From: Jamie Brown [redacted]
Sent: 06 January 2022 15:04
To: Simon Davis <Simon.Davis@arun.gov.uk>
Subject: RE: P/159/21/PL

Subject: P/159/21/PL

Please also note that application P/165/21/PL is the application for the actual access onto Spinnaker View whilst P/159/21/PL is just for changes to the Inglenook development layout. I see that you have separately responded to P/165/21/PL.

Drawing Status		Draft	
Client			
ADM Architects			
Project			
Inglenook Hotel, Pagham			
Drawing Title			
Refuse Vehicle Swept Path Analysis & Bin Collection Distances			
Scale	Date	Drawn By	Checked
1:250	June 21	SMO	ALB
Drawing No.			Rev.
2020-6289-003			B

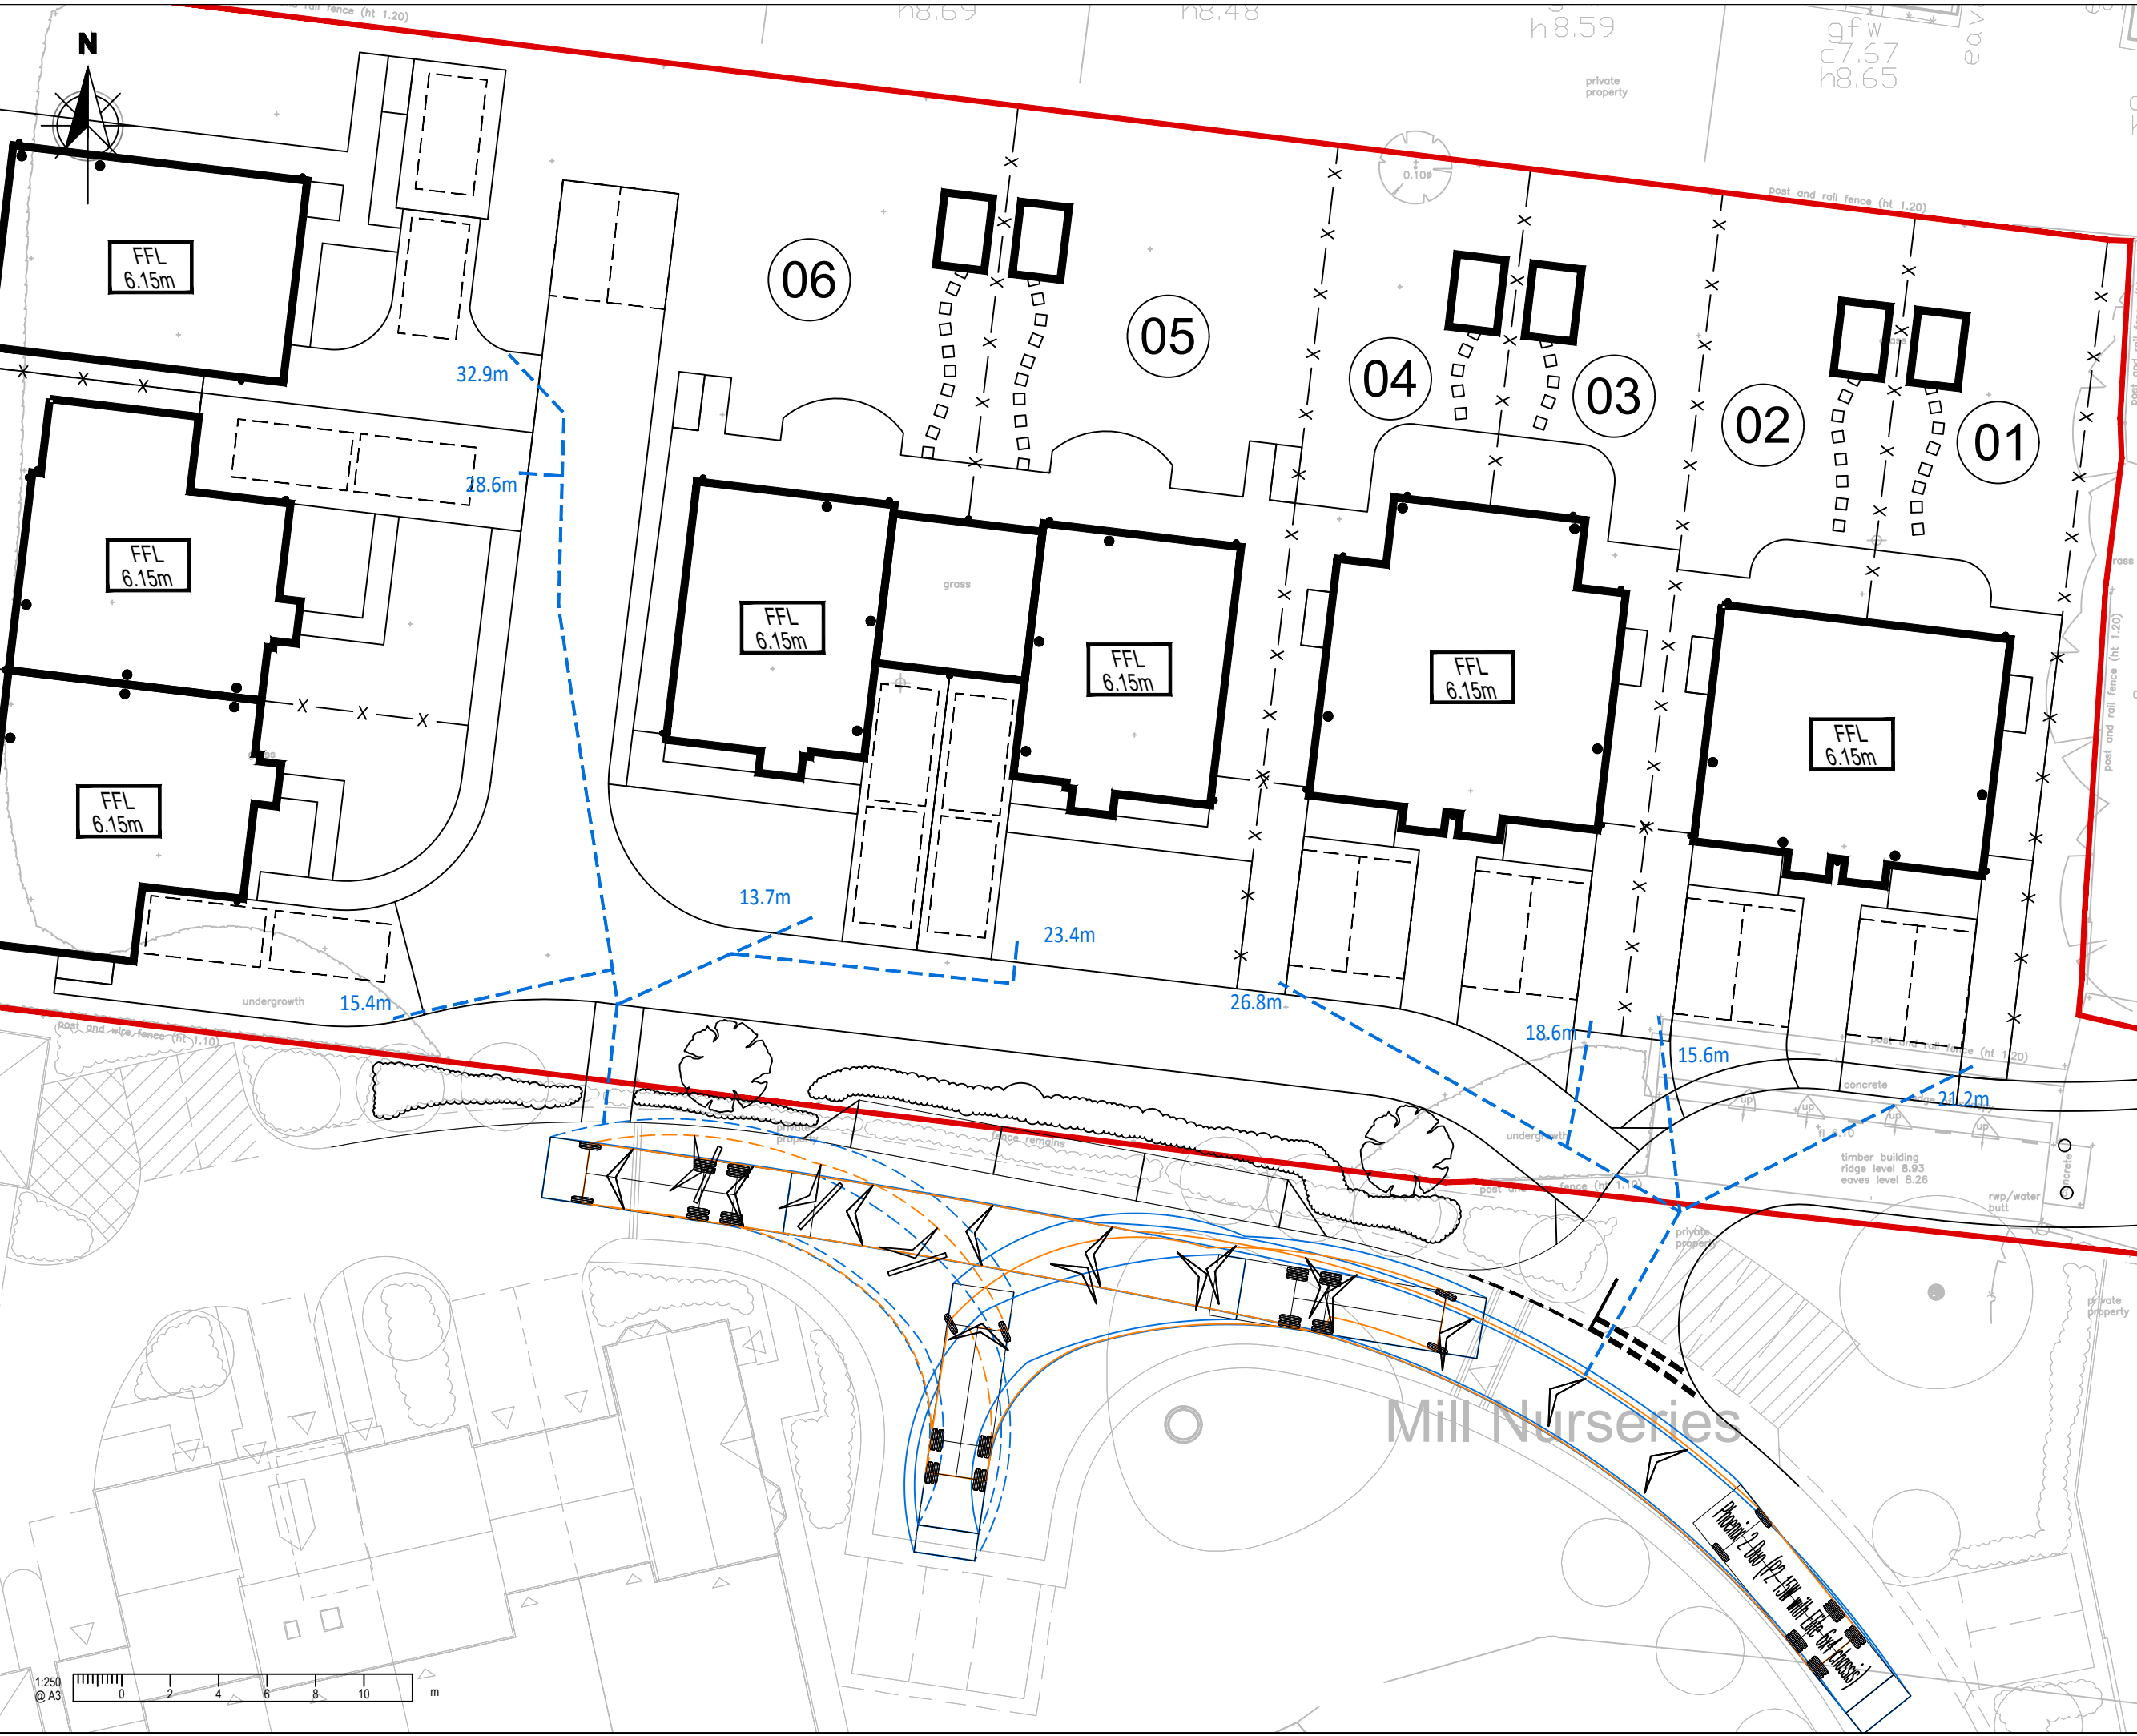
This application is attracting a lot of objections (32 so far) and will be going to Ctte therefore it is vital that consultation responses are comprehensive and do not omit parts of the scheme. I have also seen a resident objection today stating *"Turning circle is not big enough as overhang of the Fire Tender swings over plot 6 land this is because plot 9 now have an additional parking space outside their garage. If plot 6 places hedges around its perimeter what happens? This is not a big enough turning circle and not fit for purpose. If this parking space is removed from plot 9 this wouldn't be suitable for a 4-bedroom house."*

In relation to the point about the fire tender, I acknowledge the point raised by the local resident and have today requested Bright Plan to contact me regarding this matter and we will look to request a further plan. I will therefore be in touch.

Drawing Status	Final
Client	ADM Architects
Project	Inglenook Hotel, Pagham
Drawing Title	Site Overview
Scale	1:500
Date	Dec 21
Drawn By	SMO
Checked	ALB
Drawing No.	2020-6289-001
Rev.	E

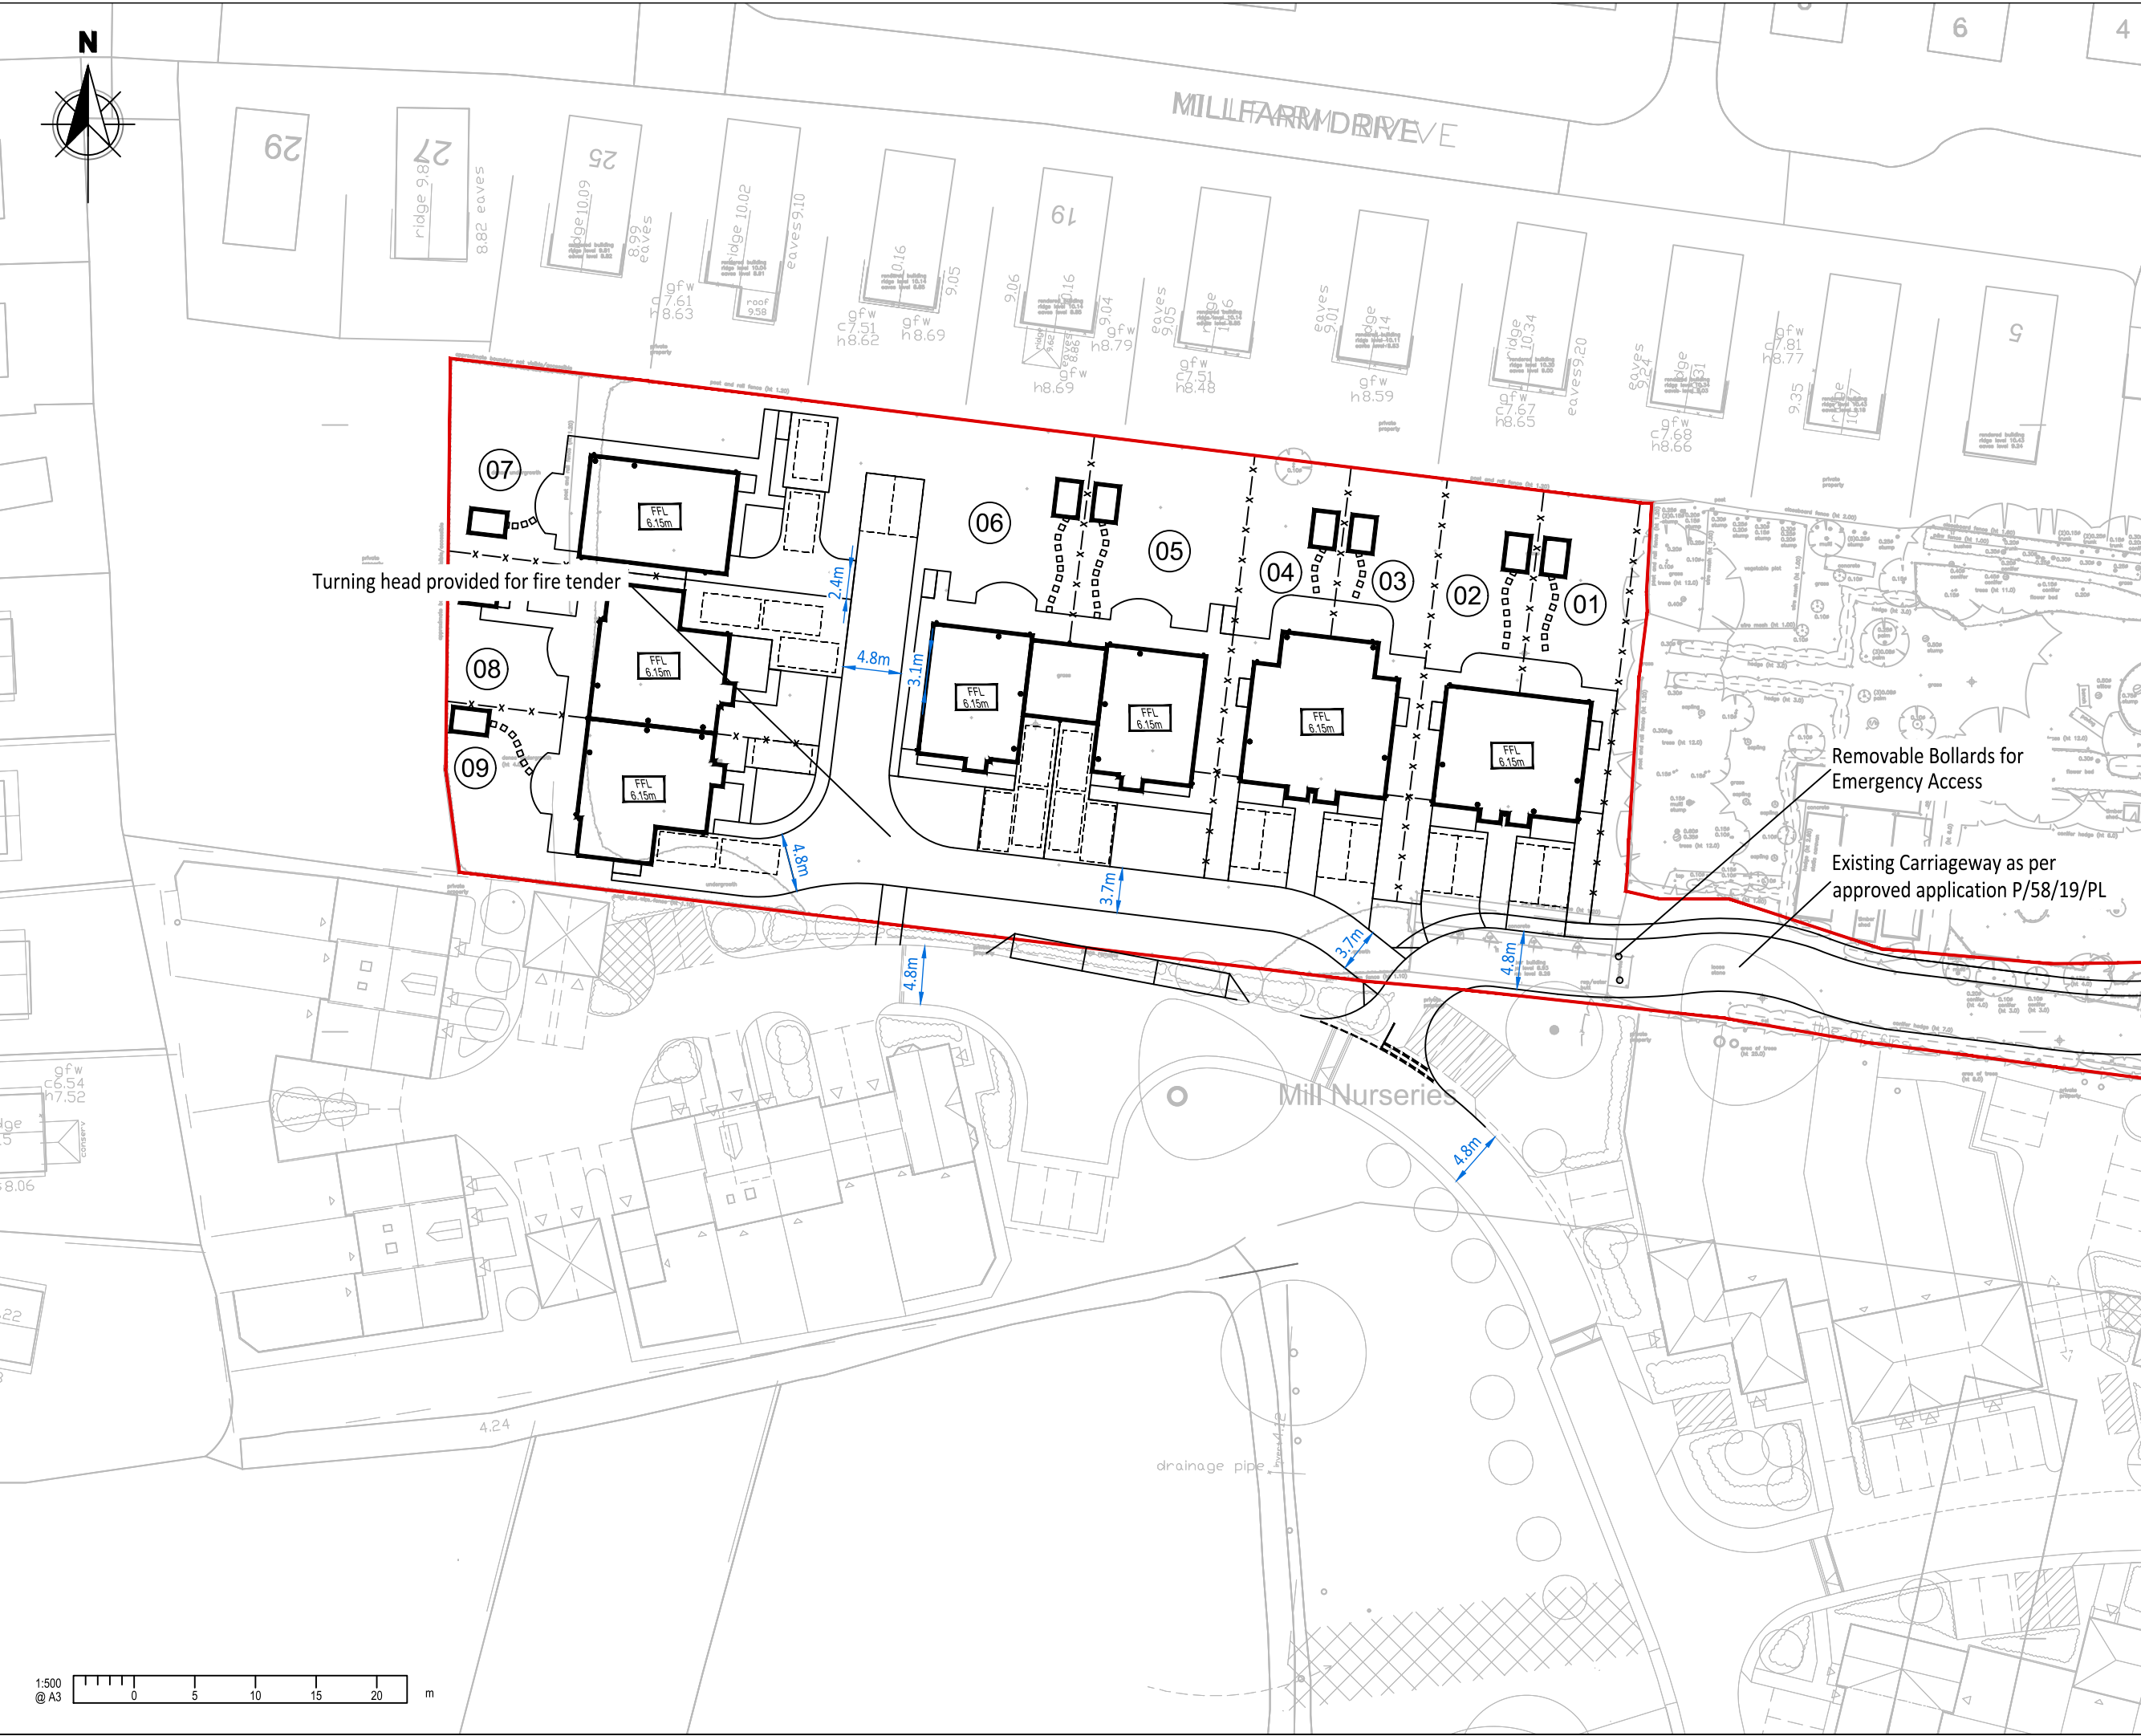
"In principle the parking arrangements are as previously approved under P/58/19. Some changes have been incorporated in the form of the removal of 3 visitor parking bays which have been provided as parallel parking to the west of the site."

Could you look at this again/revise your comments as they have added 4 extra parking spaces to the layout. This was at my request due to the extra demand created by the additional bedrooms in plots 5, 6, 8 & 9 (see my email attached explaining this).

Thanks for your email and our chat yesterday. When reviewing the application I reviewed the plans within the Technical Note from Bright Plan which didn't include the latest plan which you refer to. I have now reviewed this as you have requested and would agree the extra parking proposed would be welcomed.
